Application for a non-material amendment following a grant of planning permission.

Two storey rear/side extension involving demolition of existing garage and walkway and single storey detached garage to front

Reference number:	FP/192/19/HH
Date of decision	12/11/2019

0032-03A Proposed Plans
0032-06A Proposed Elevations

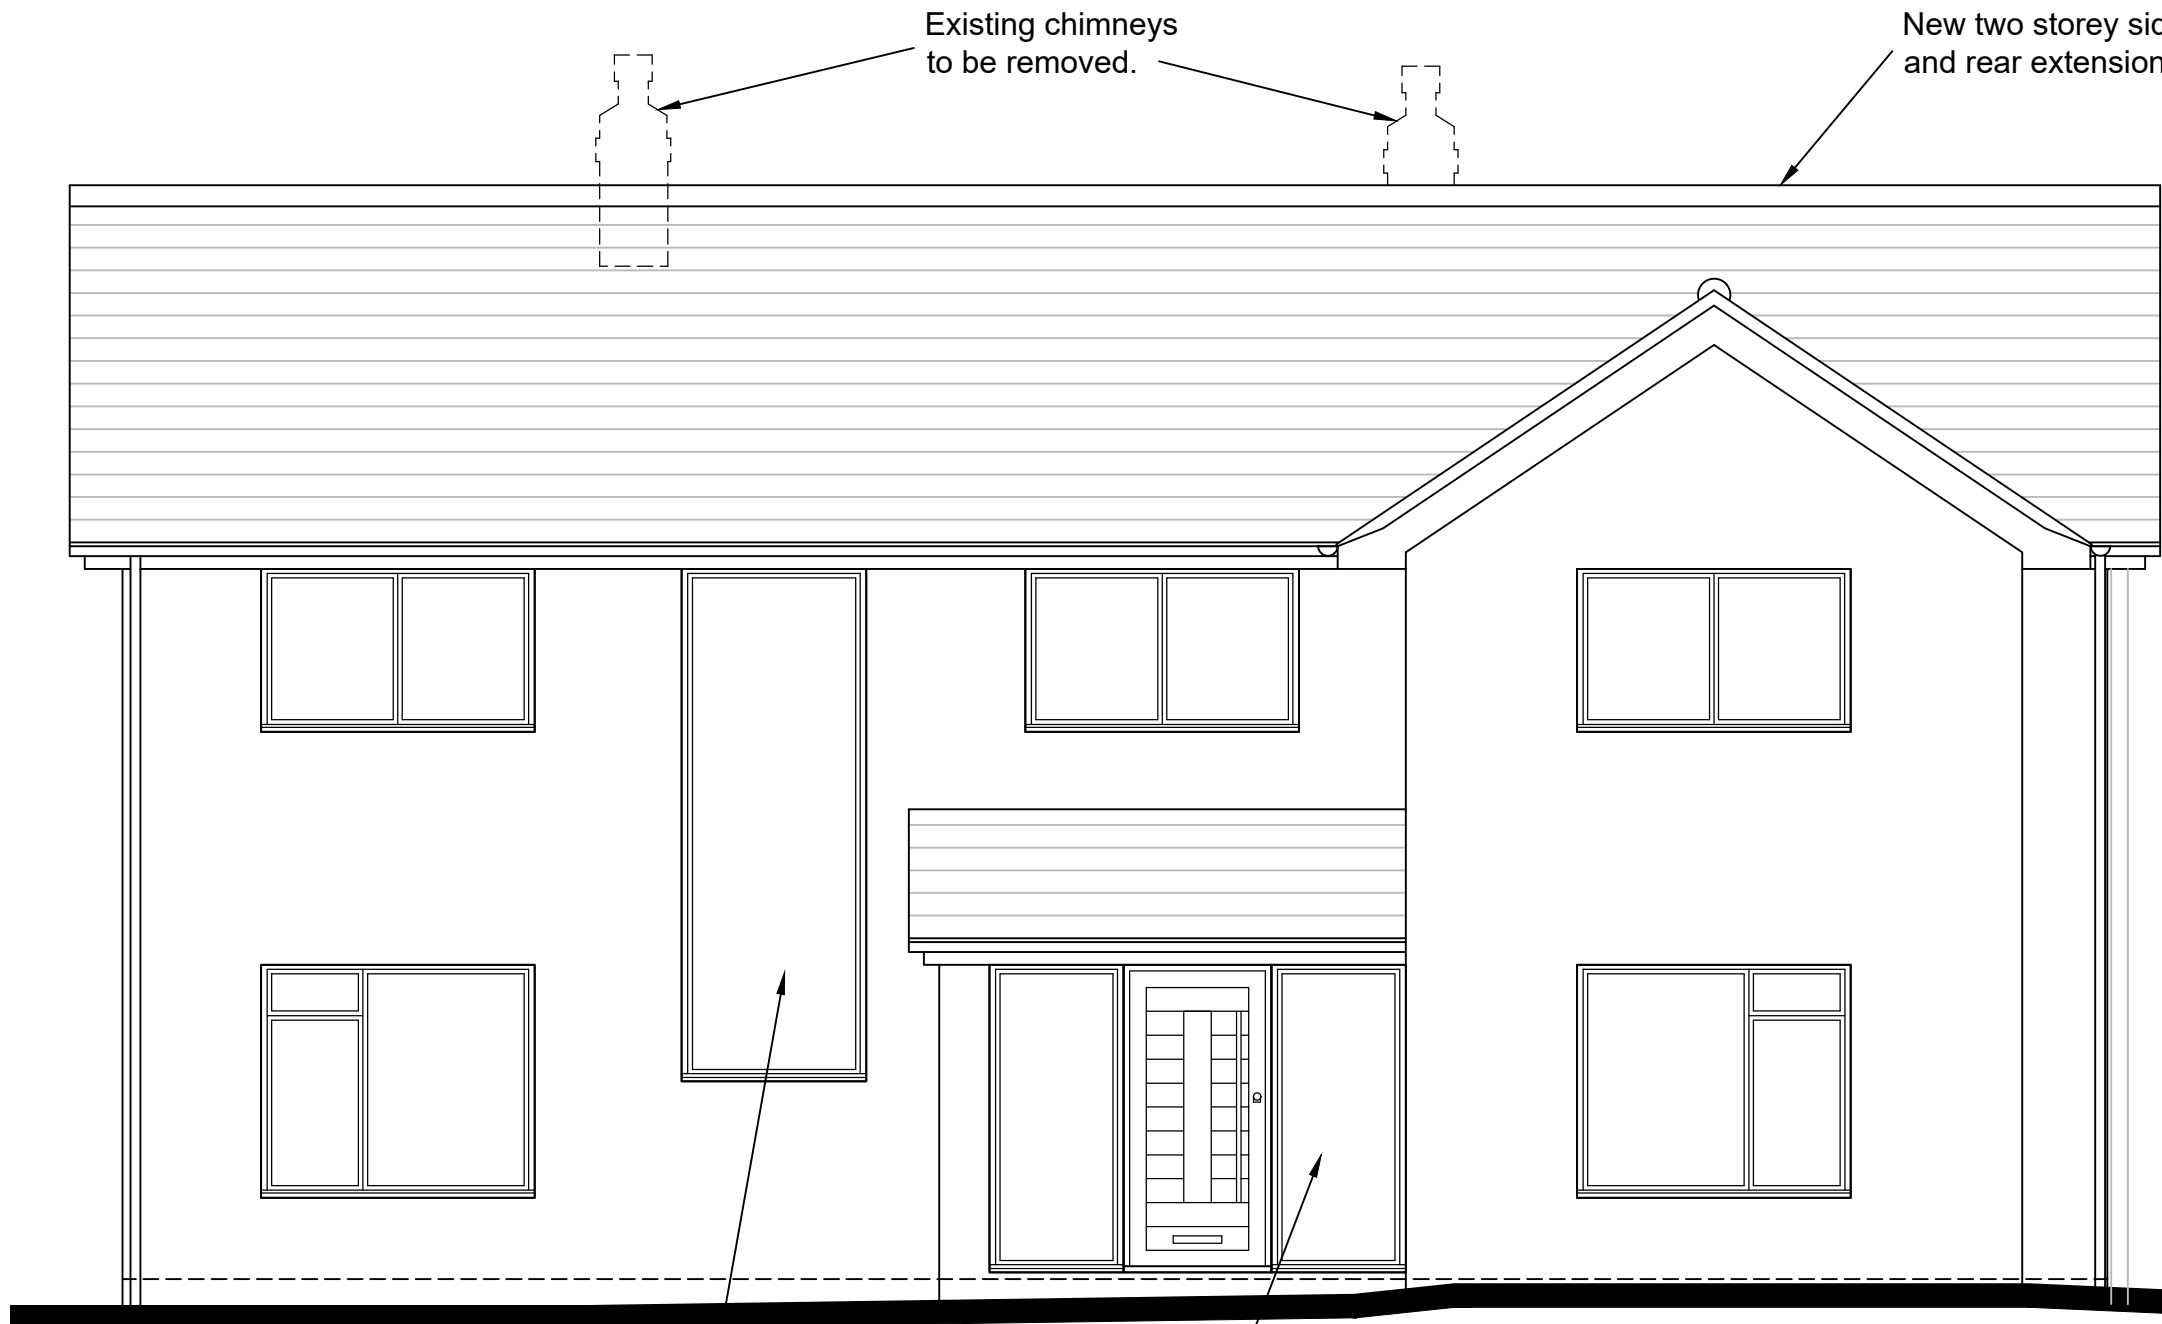
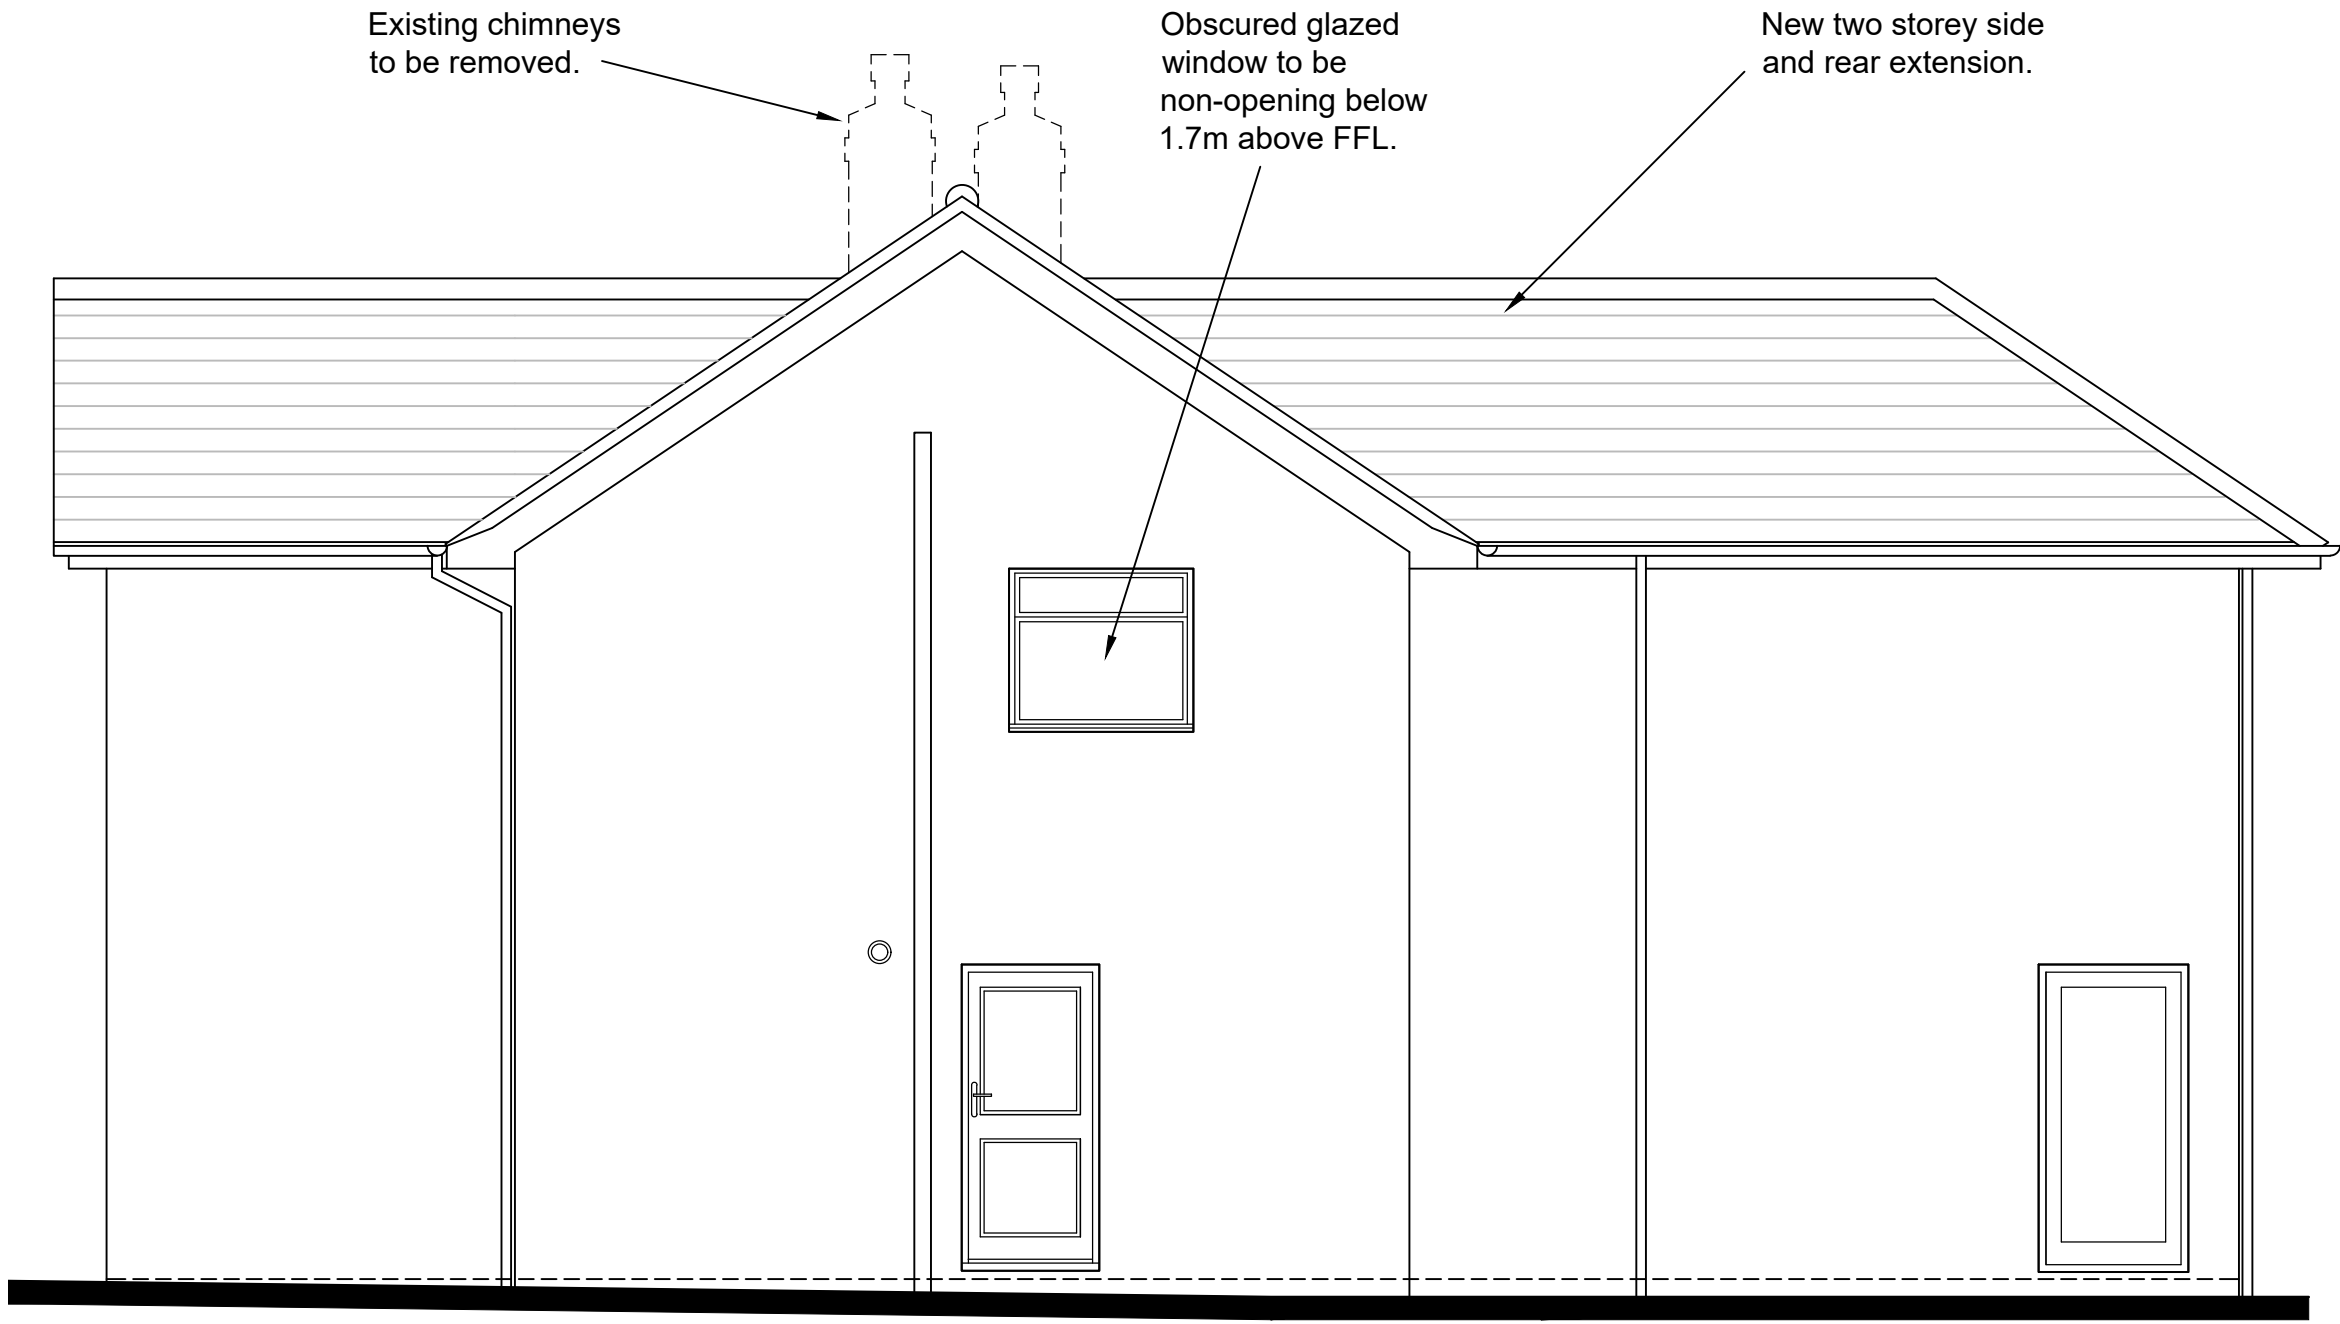
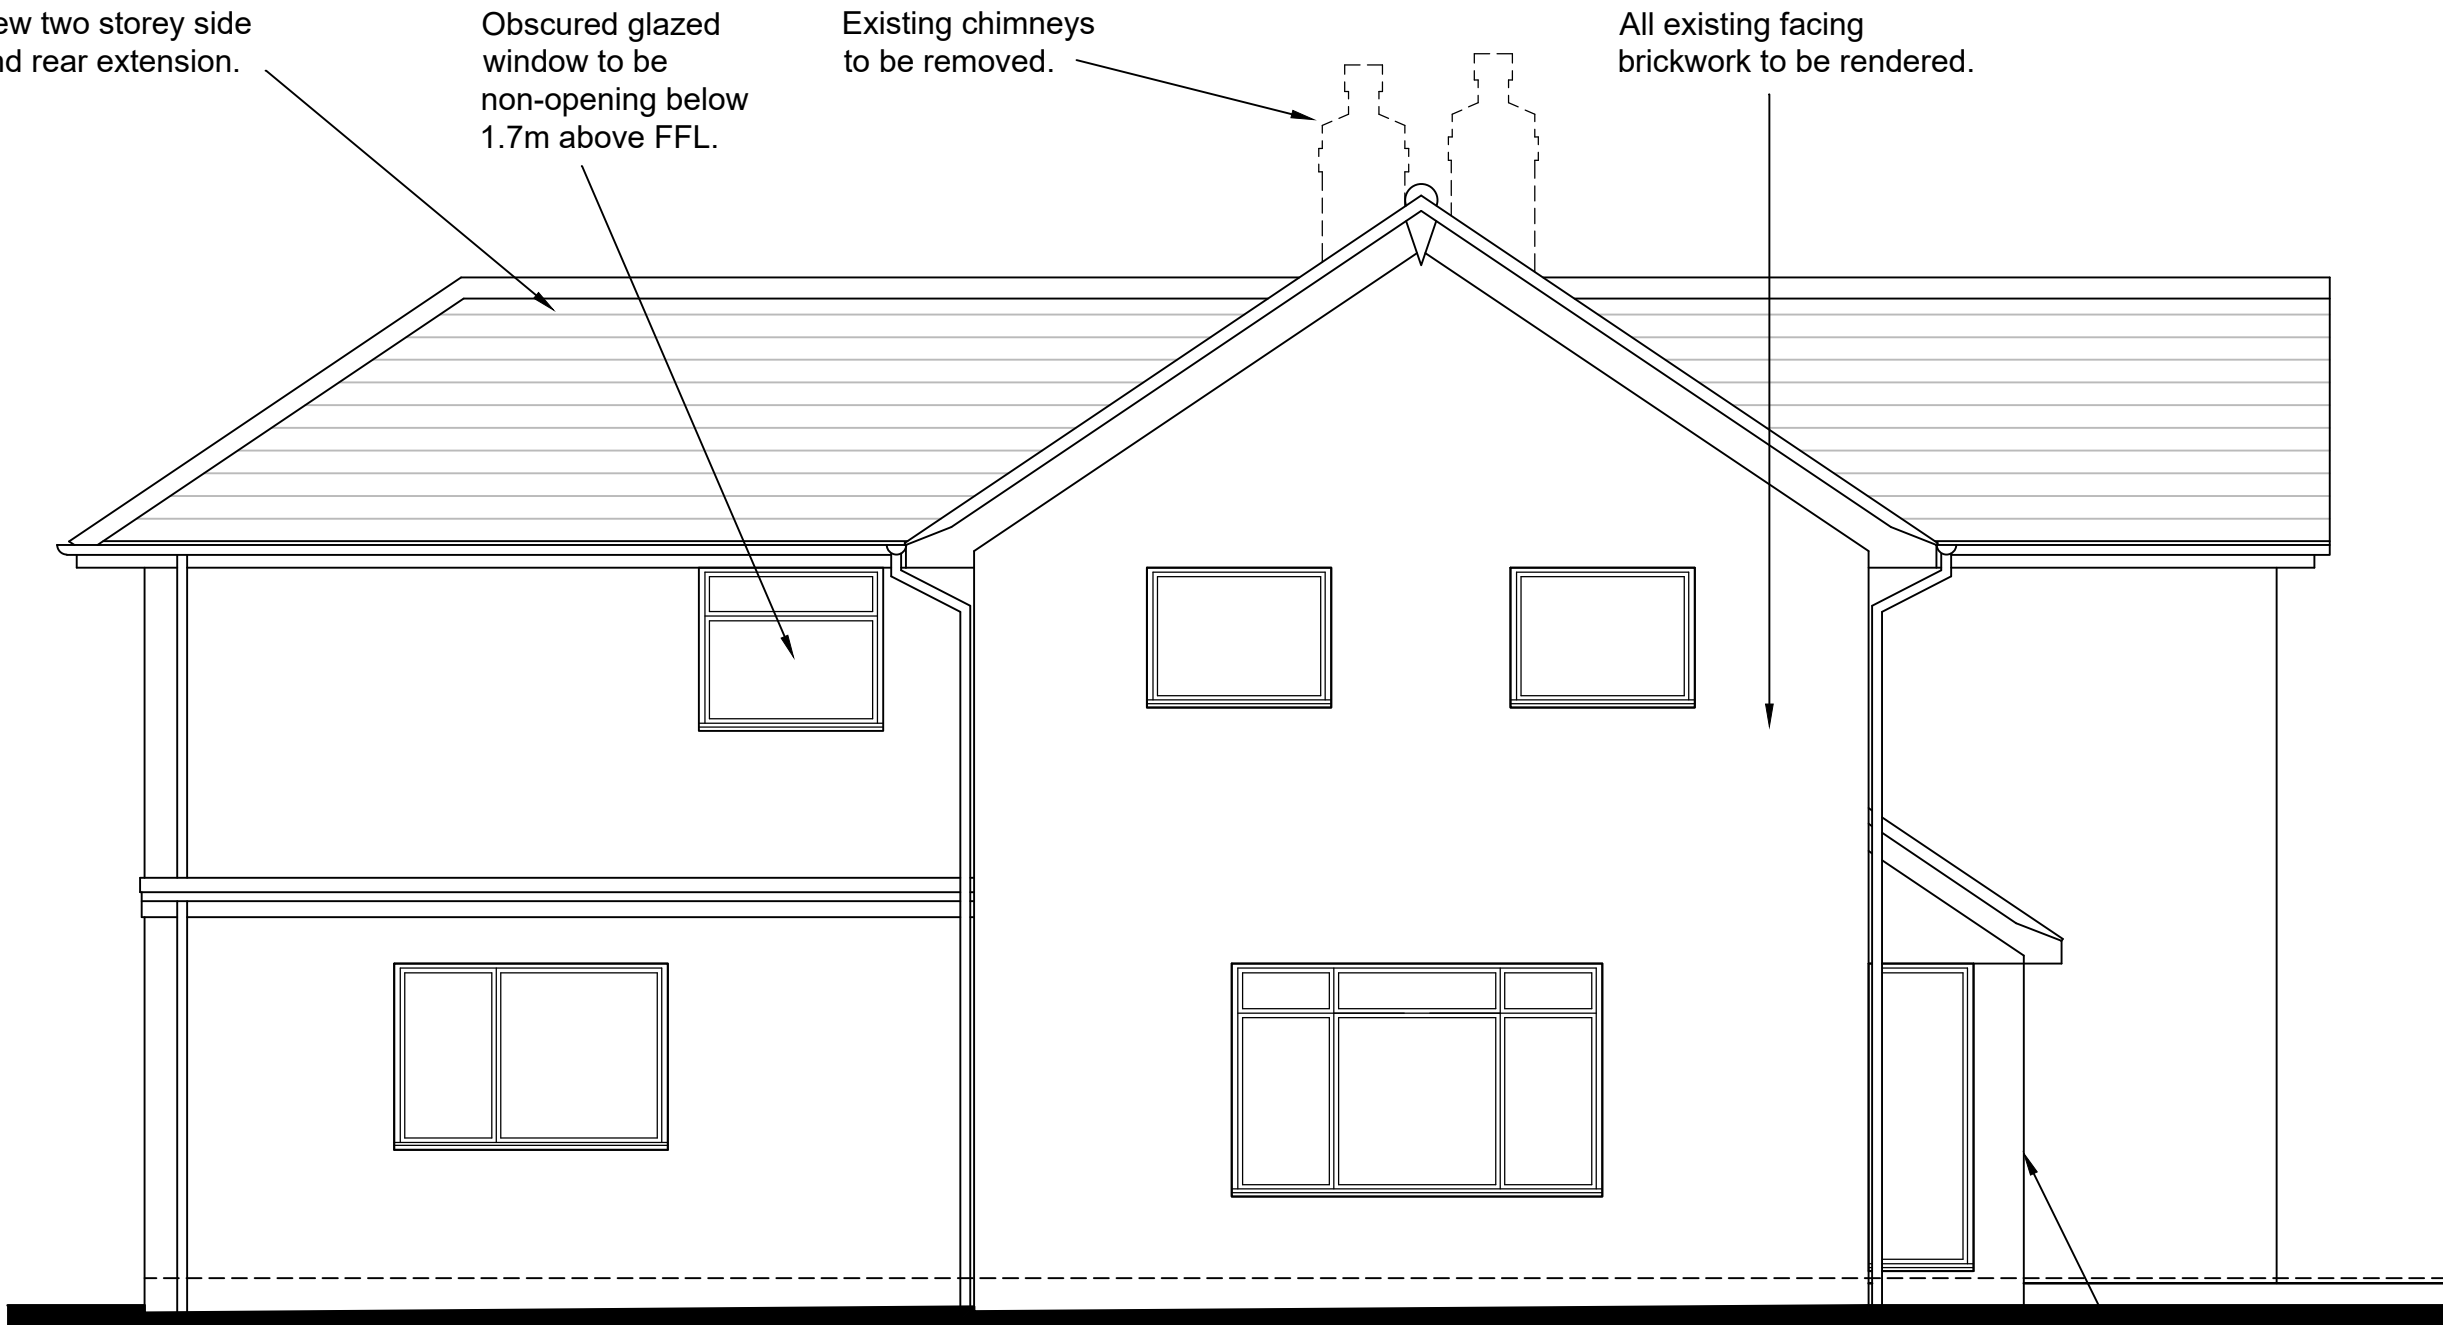
Addition of first floor Dressing Room obscured glazed window, only openable above 1.7m above finished floor level and alteration to Family Bathroom window to be obscured glazed and only openable above 1.7m above finished floor level.

The addition of the Dressing Room window is to provide daylight to the Dressing Room as it currently has no window.
The alteration to the Family Bathroom window is to accord with planning condition 3 of the current planning permission.

0032-03B Proposed Plans
0032-06B Proposed Elevations
